Recommendation Report for Planning Permission

REF NO: CM/17/21/PL

LOCATION: Land at Wren Cottage
Horsemere Green Lane
Climping
BN17 5QZ

PROPOSAL: Development of 2 No. 2-bed & 2 No. 3-bed detached dwellings & associated works (resubmission following CM/53/20/PL). This site is in CIL Zone 3 & is CIL Liable as new dwellings.

PLOT 1 FLOOR PLANS
SCALE 1:100 @ a3

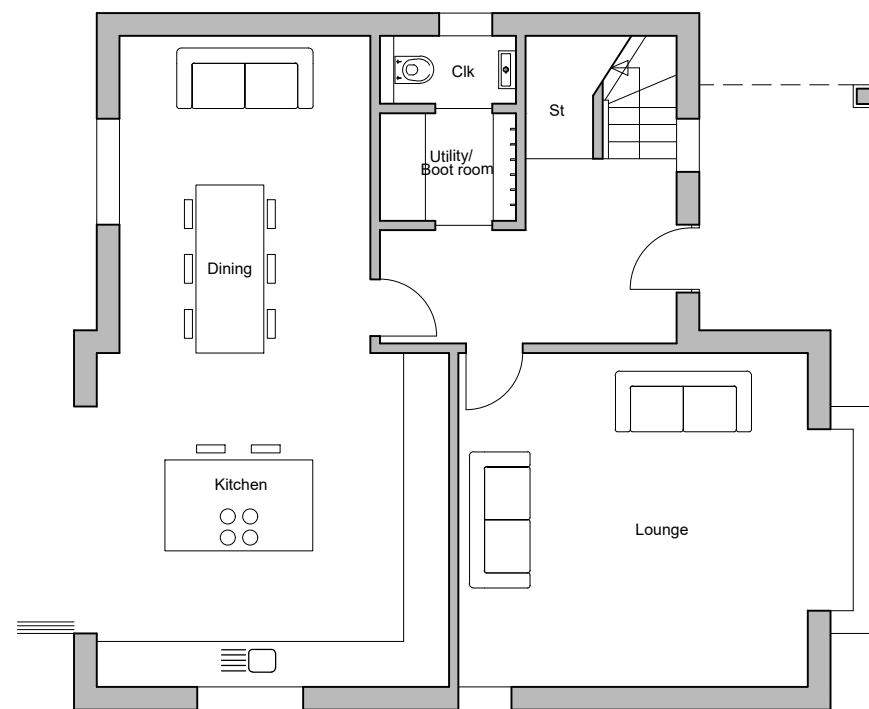
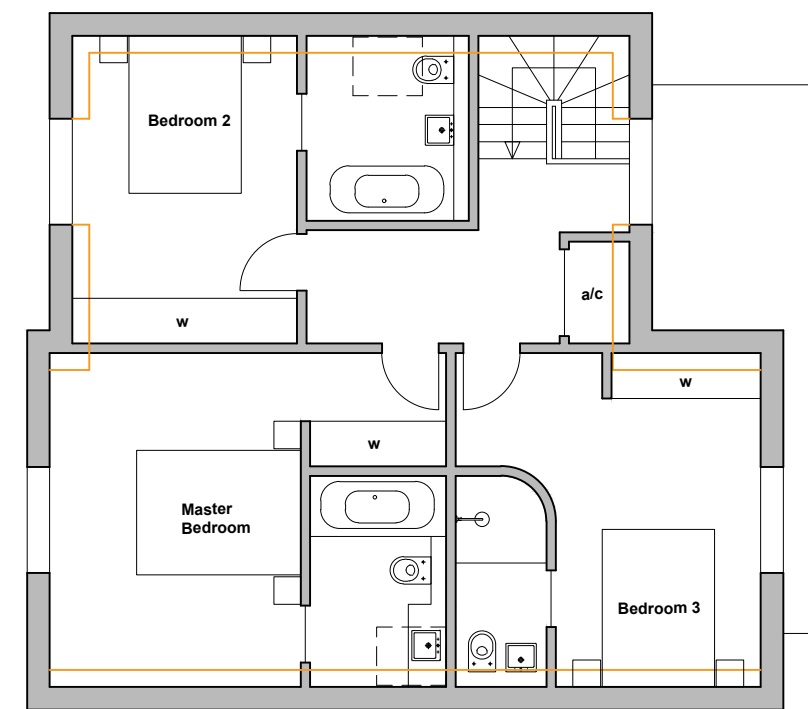
- Proposed properties remain between 10.1m - 11.6m from the boundary to the west. None are over 12m from that boundary.
- Plot 1 has not been amended and remains a two storey dwelling and has a distance to 4 Wooldridge Walk of 21m. The property is sited 10.6m from the rear boundary.

PLOT 2 FLOOR PLANS
SCALE 1:100 @ a3

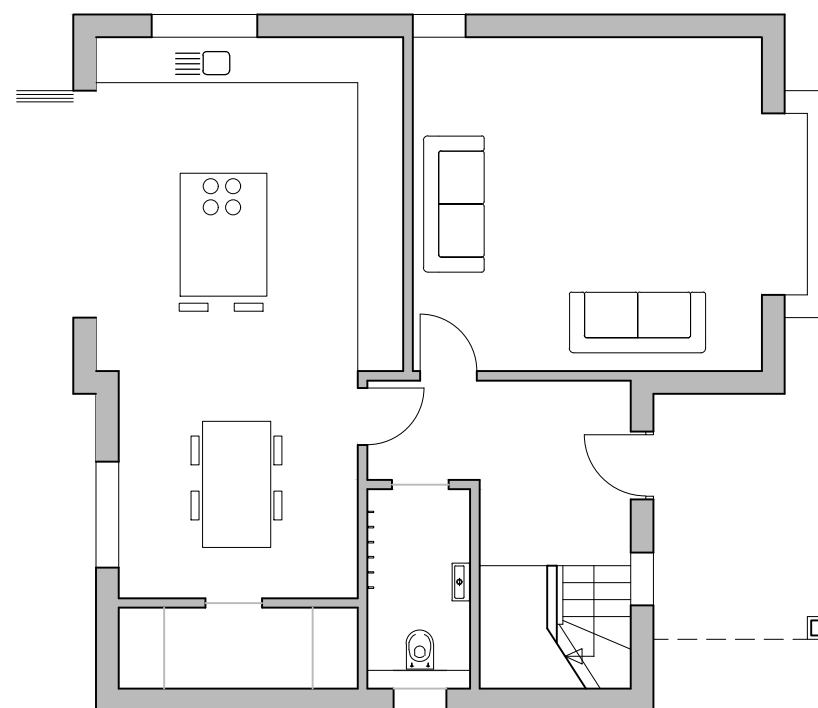
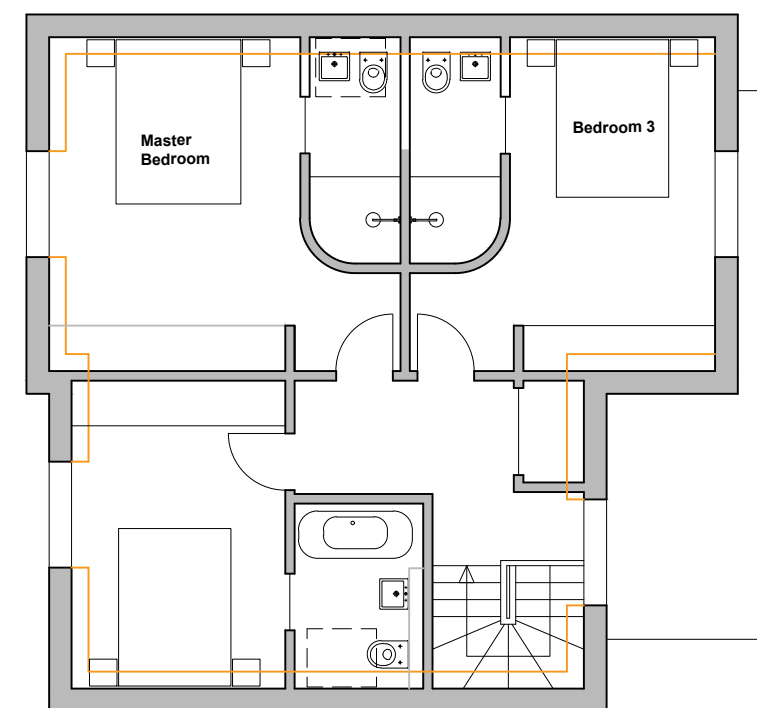
- Officers raised concerns regarding the plot 2 and its relationship with adjoining properties previously. Whilst the length of the rear garden has been increased, it is below the 10.5m required in the Design Guide and a distance of 5.6m is provided to the rear of properties in Wooldridge Walk; well below the required 21m.

- Plot 2 has been amended to reduce the ridge height by only 0.86m. Rear facing first floor windows are proposed, even though they are rooflights. The property is only 10.1m from the boundary and the distance to the rear of 5 Wooldridge Walk is only 15.6m.

PLOT 1 ELEVATIONS
SCALE 1:100 @ a3

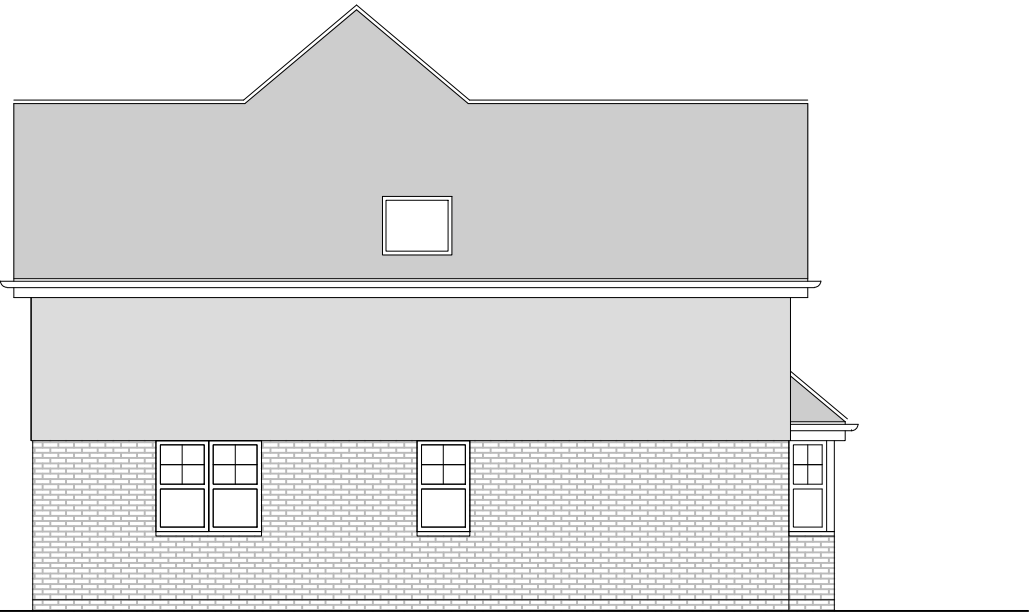
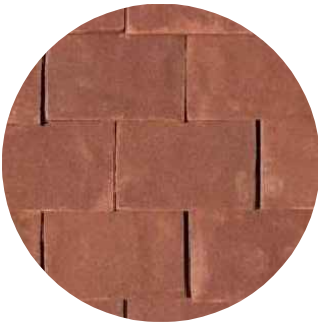
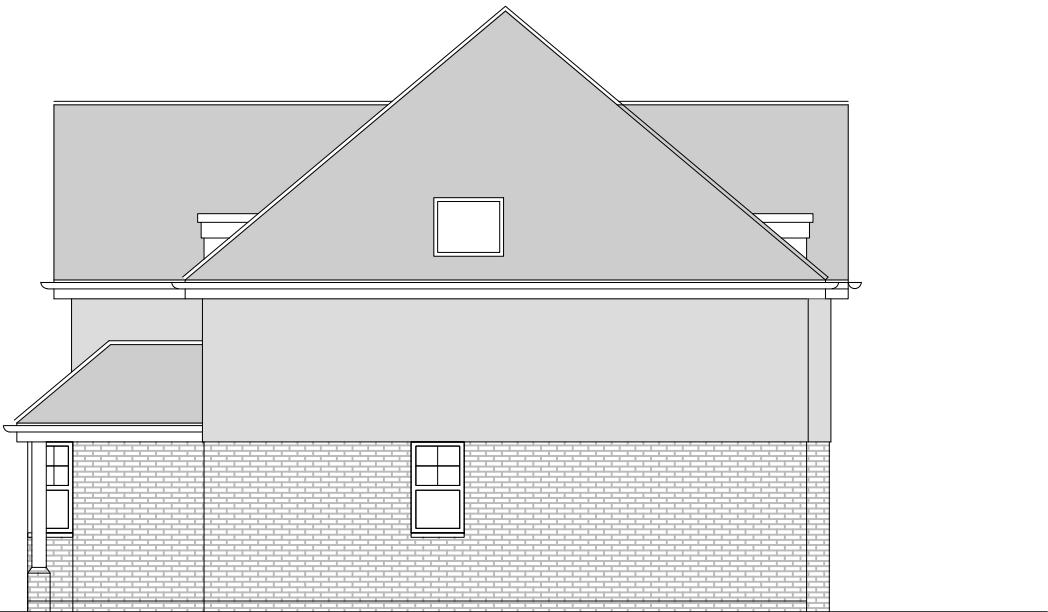
- None of the properties have been re-sited to be a minimum of 12m.
- Had plot 1 been sited over 12m from the boundary, it is considered that this would be acceptable.
- Whilst windows to first floor habitable rooms may have been removed from the rear of plots 2 - 4, the proposed properties retain windows that face the properties to the west. These, combined with the inadequate distance separation, will result in the significant perception of overlooking.
- Only one relationship exceeds the 21m guidance. In this case, it is only just satisfied and is from a proposed two storey dwelling to a single storey dwelling.
- Three other relationships fall short of the 12m to boundaries and 21m distance separation.

PLOT 3 FLOOR PLANS
SCALE 1:100 @ a3

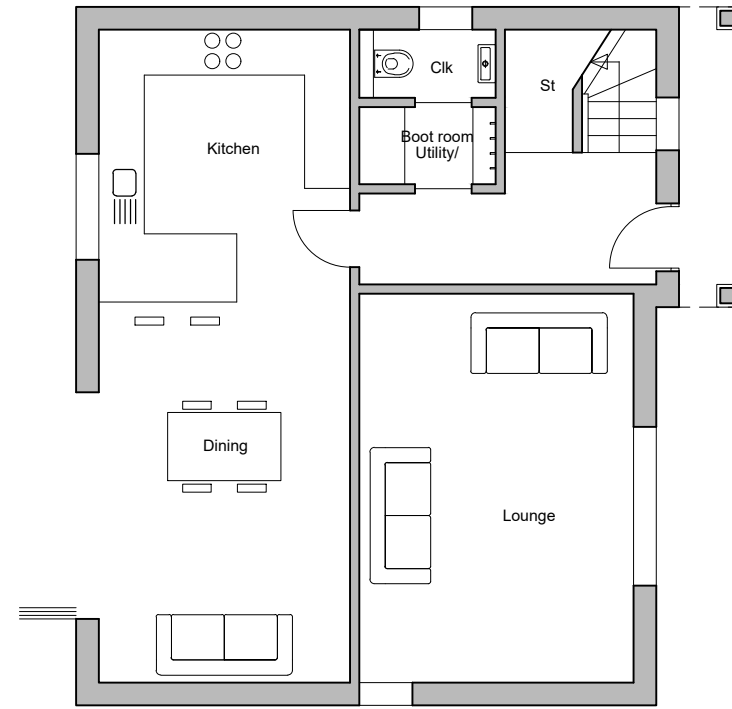
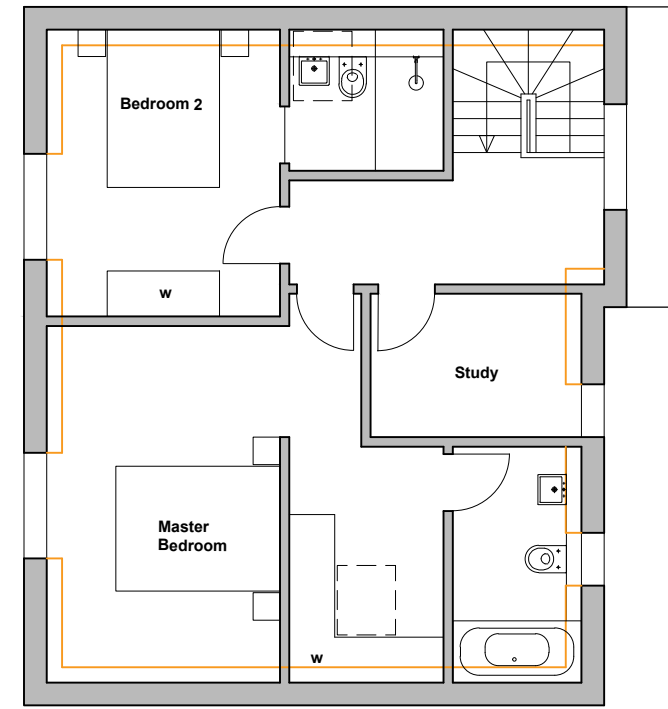
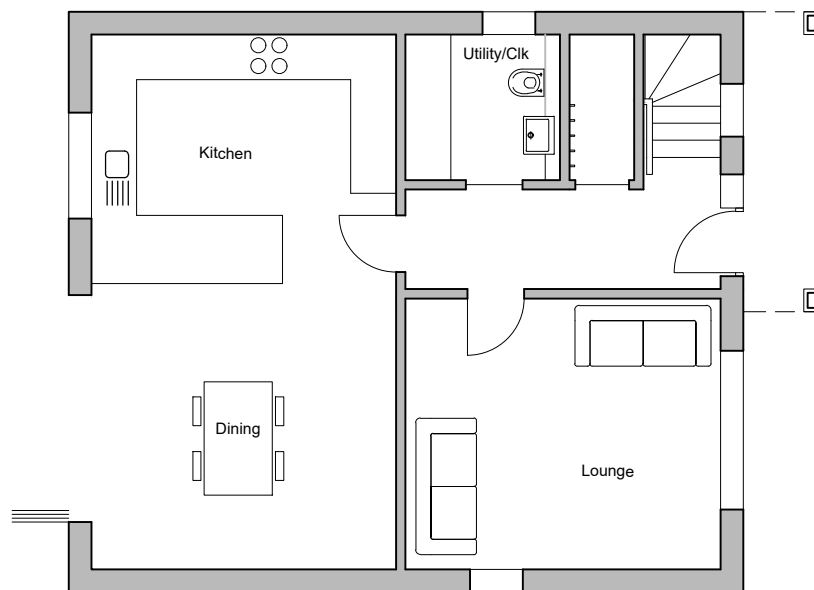
- Plot 3 been amended to reduce the ridge height by only 1m. Rear facing first floor windows are proposed, even though they are rooflights. The property is 11.2m from the boundary and the distance to the rear of 6 Wooldridge Walk is 22m but only 18.7m to the rear of 7 Woodridge Walk.

PLOT 4 FLOOR PLANS
SCALE 1:100 @ a3

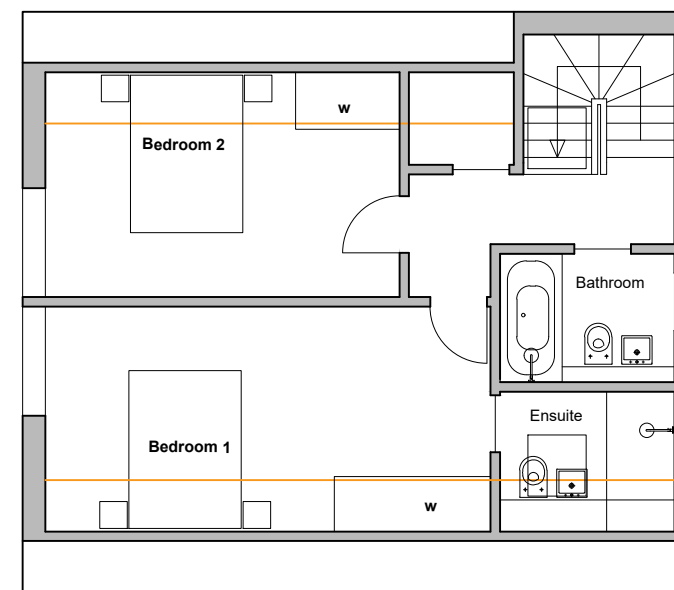
Officers raised concerns regarding the relationship with 30 Appletree Walk during consideration of the previous proposals. This was due to the siting of Plot 4 relative to the boundary and the height of the proposed dwelling. Plot 4 has been moved slightly further from the boundary and the dwelling is of a reduced scale sufficient to overcome previous concerns.

- Plot 4 has not been amended in siting or scale. Rear facing first floor windows are proposed and these are not rooflights. The property is only 10.9m from the boundary and the distance to the rear of 7 Wooldridge Walk is 20.3m and 18.7m from the rear of 8.
